**WEST SUSSEX COUNTY COUNCIL
INFRASTRUCTURE CONSULTATION**

SUBJECT: R/278/10

40 Broadmark Lane, Rustington

Retrospective application for a vehicular crossover

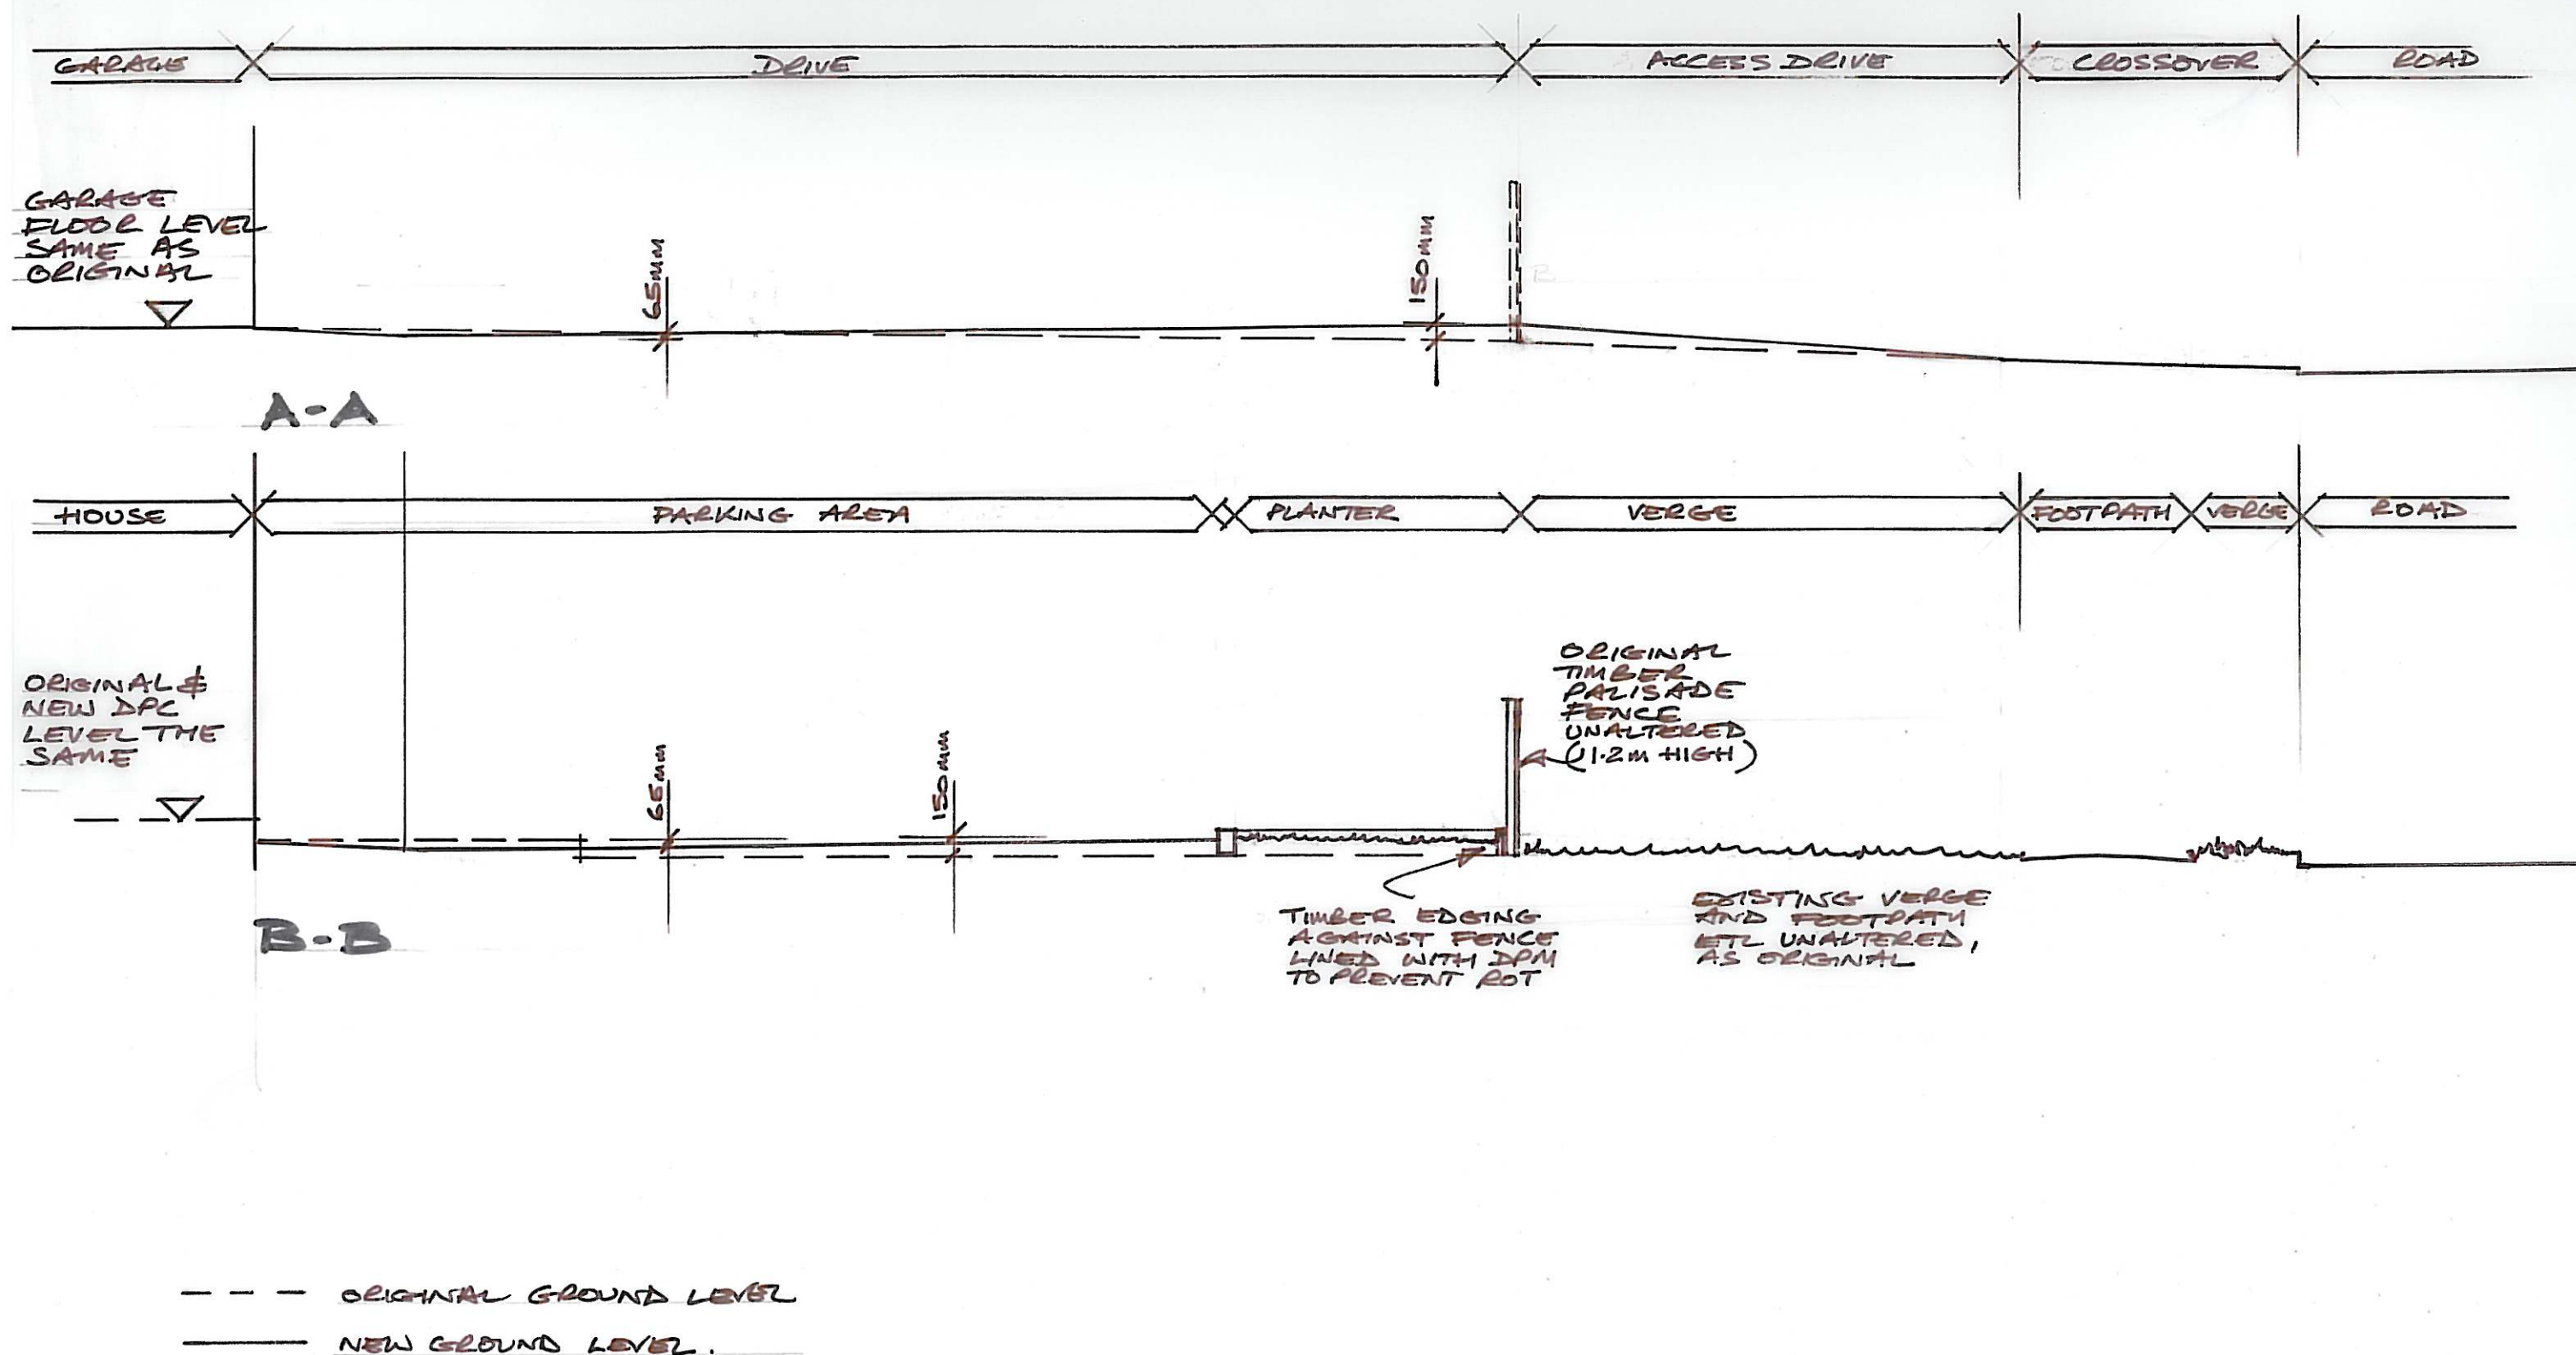
WSCC would not be minded to raise any safety concerns regarding the gradient of the access, providing that it does not exceed 1:10 for the first 5.5m back from the carriageway and from an inspection of the drawings this would appear to be the case. The Applicant would also be advised that no surface water should discharge onto the public highway.

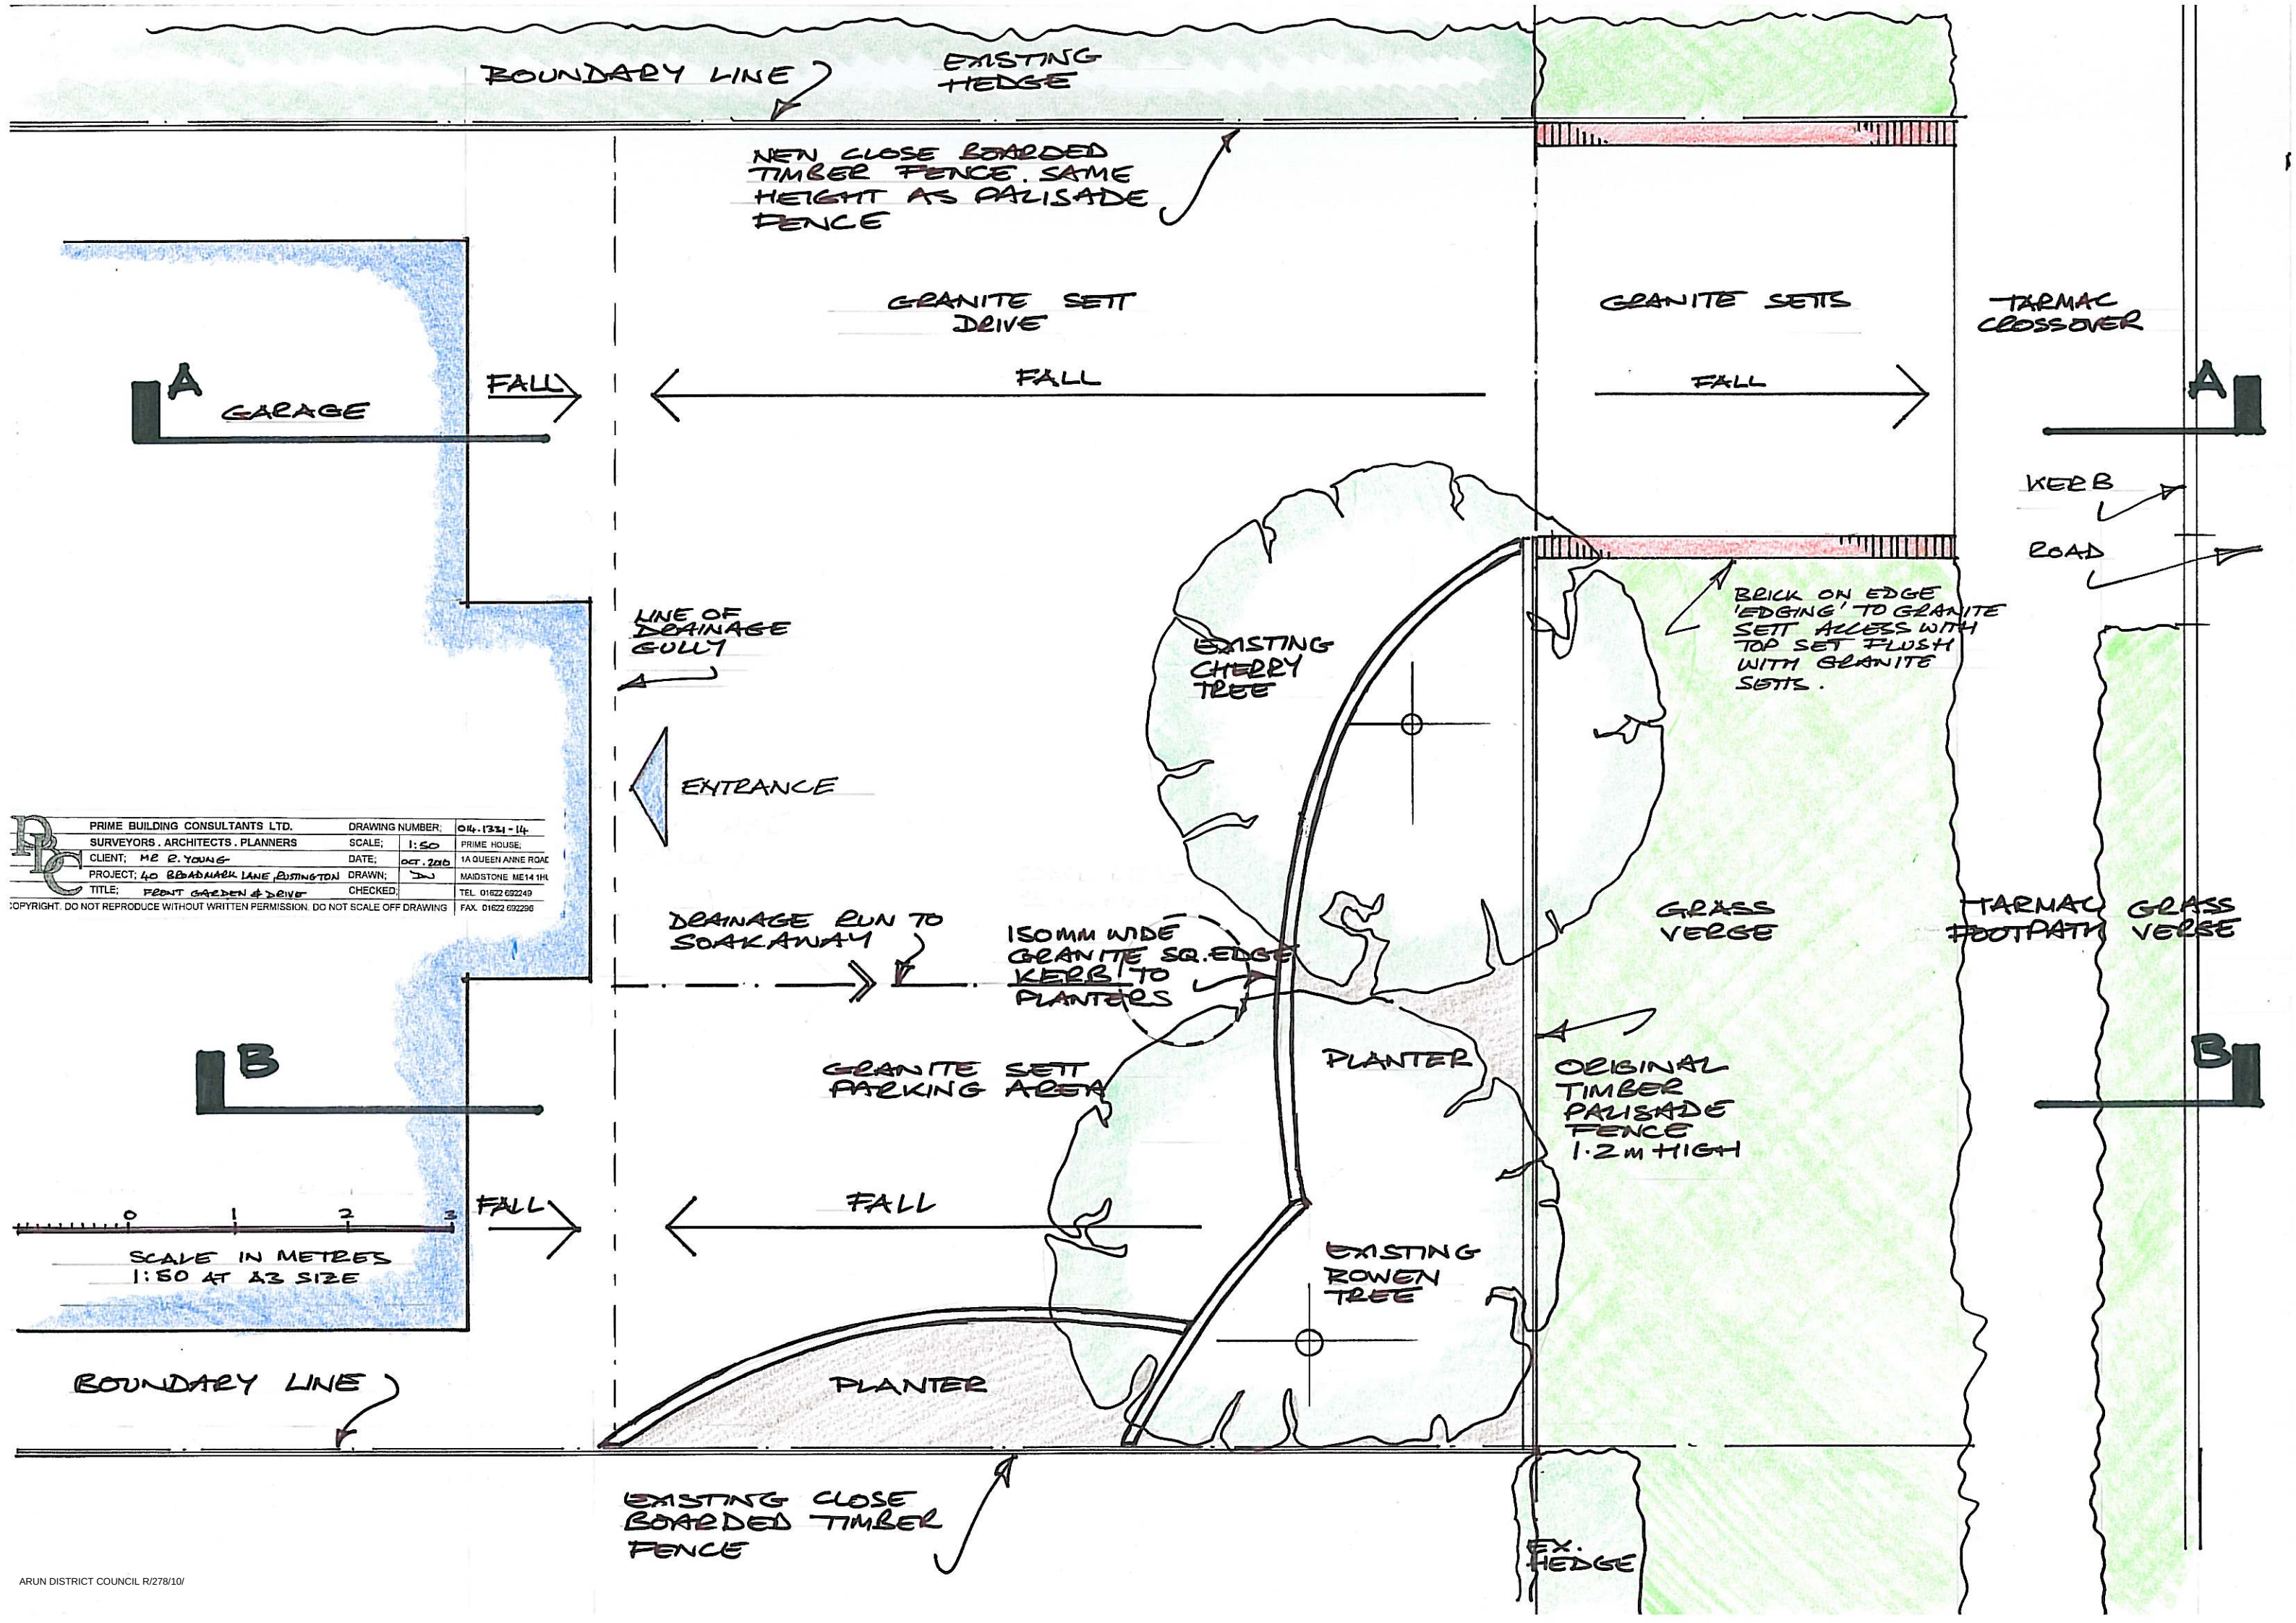
The application is for retrospective permission for a vehicular crossover onto Broadmark Lane. From an inspection of the plans alone, there is no apparent visibility issue from this access onto Broadmark Lane, and the most recently available verified accident records reveal there have been no personal injury accidents in this location. WSCC would recommend, however, that pedestrian visibility of 2x2m be provided at the access in the interests of pedestrian safety – and this would require the arrangements to be modified.

The access should be constructed to a specification which meets the approval of the Area Engineer (Western); however WSCC would advise that the crossover should be constructed from a bound material for the first 5m back from the highway to prevent loose material from being dragged onto the highway. An acceptable arrangement for the control of loose material can be discussed with the Area Engineer.

In summary, WSCC would not raise any highway safety objections to this vehicular crossover. However, the Applicant should modify the crossover to comply with the advice provided above in order to ensure that the access meets the correct highway specification.
